SHERIDAN STREET ADDENDUM #1 MECHANICAL, PLUMBING & ELECTRICAL

Date: February 28, 2014
 Scale: 1/4" = 1'-0"
PLUMBING DETAILS AND SCHEDULES

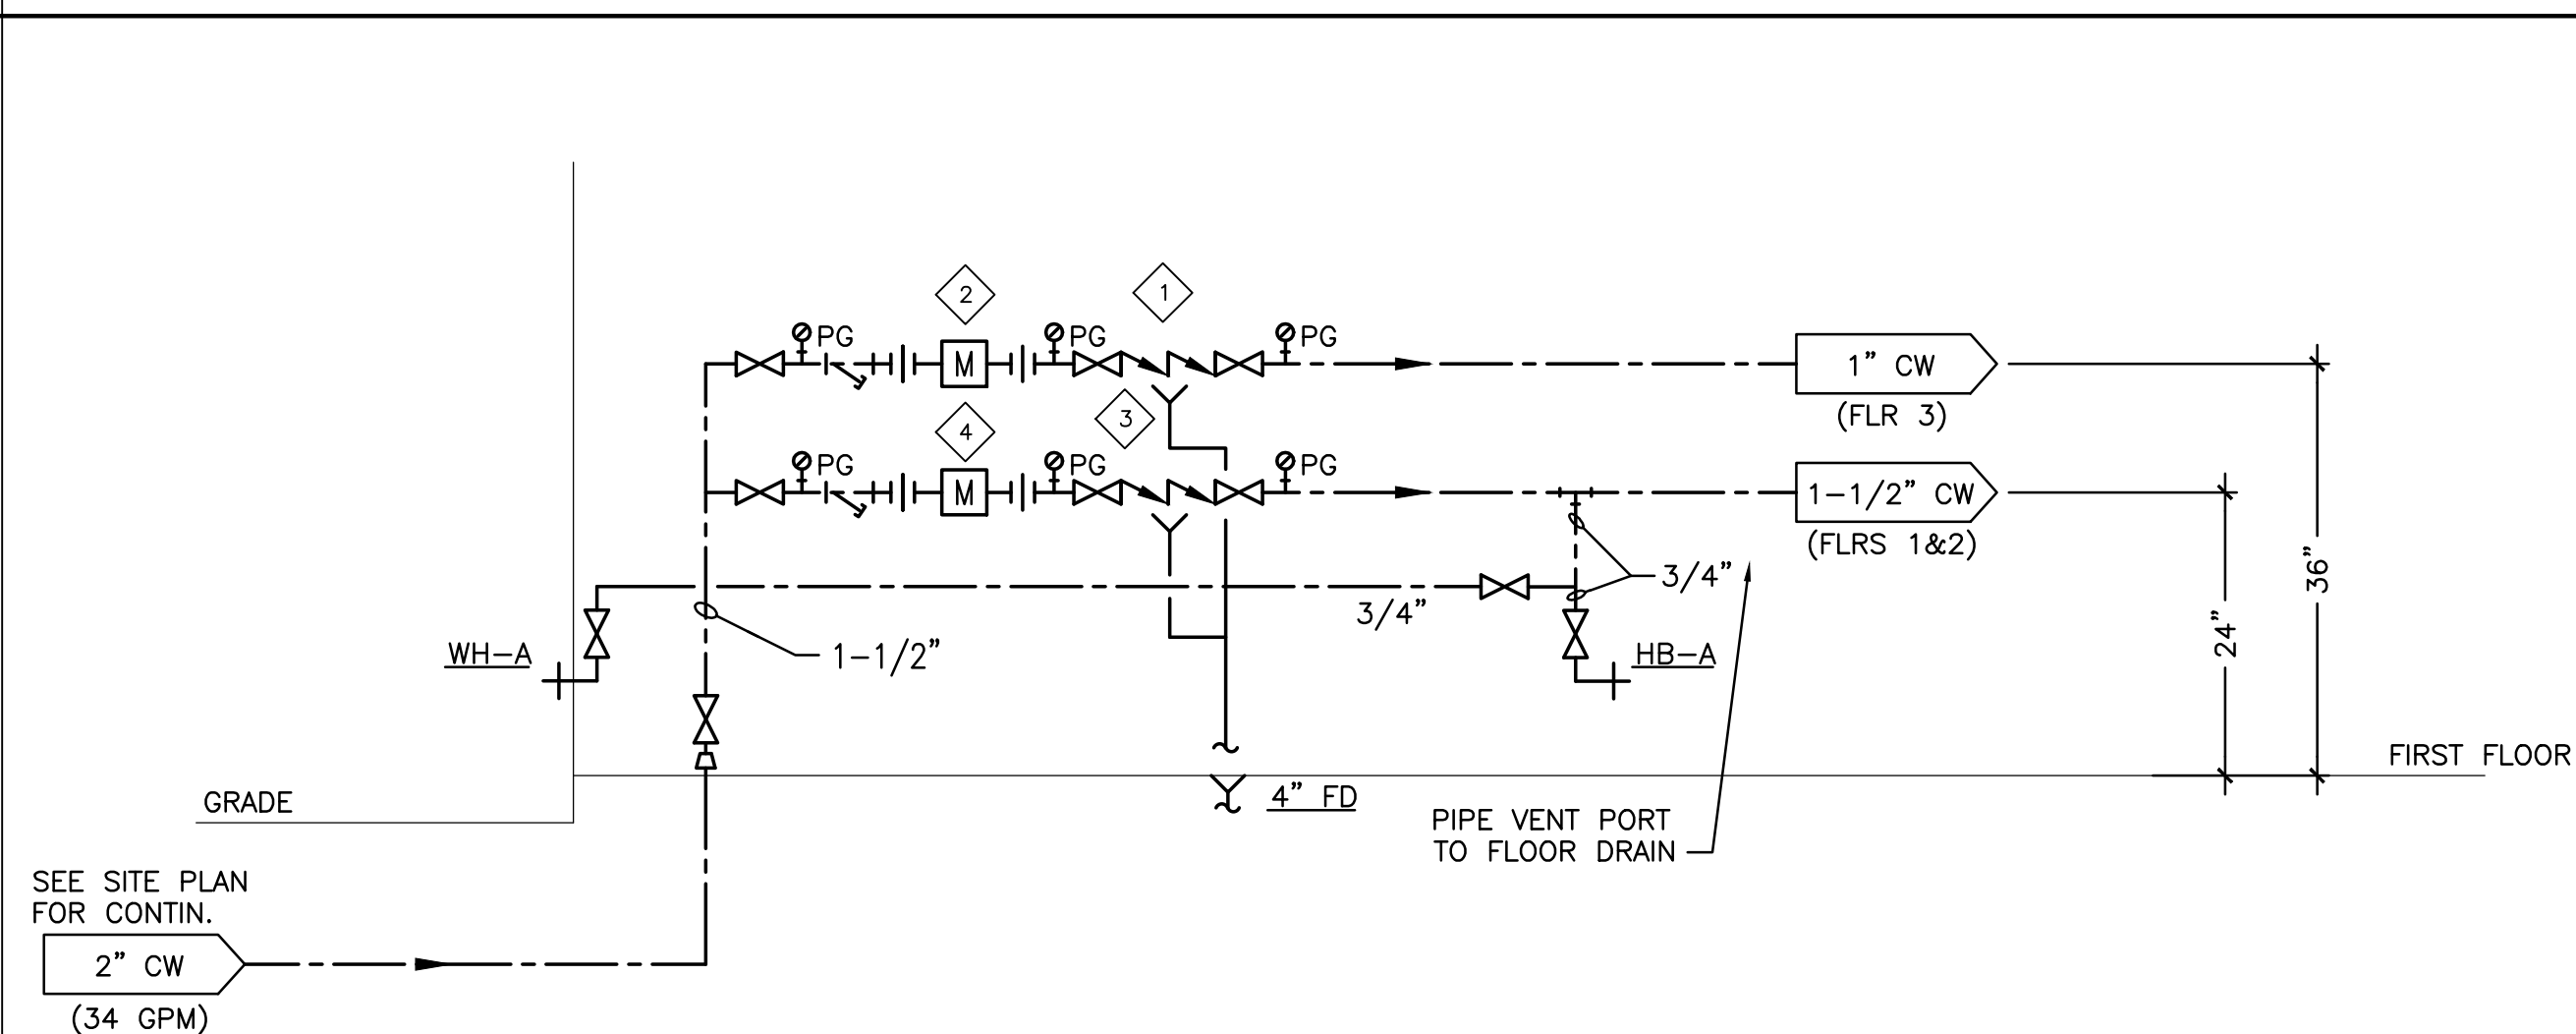
Sheet P3.0 – Added LAV-B and SK-B and BT-B fixtures information to match fixtures on lower floors, revised shower fixtures to include shower pan only. Added SHR-D with 1 gpm shower head for studio due to size of instantaneous water heater. Revised WH-3 in water heater schedule. Revised water entrance schematic to show one city water meter for the entire building, and one submeter for the 3rd floor.
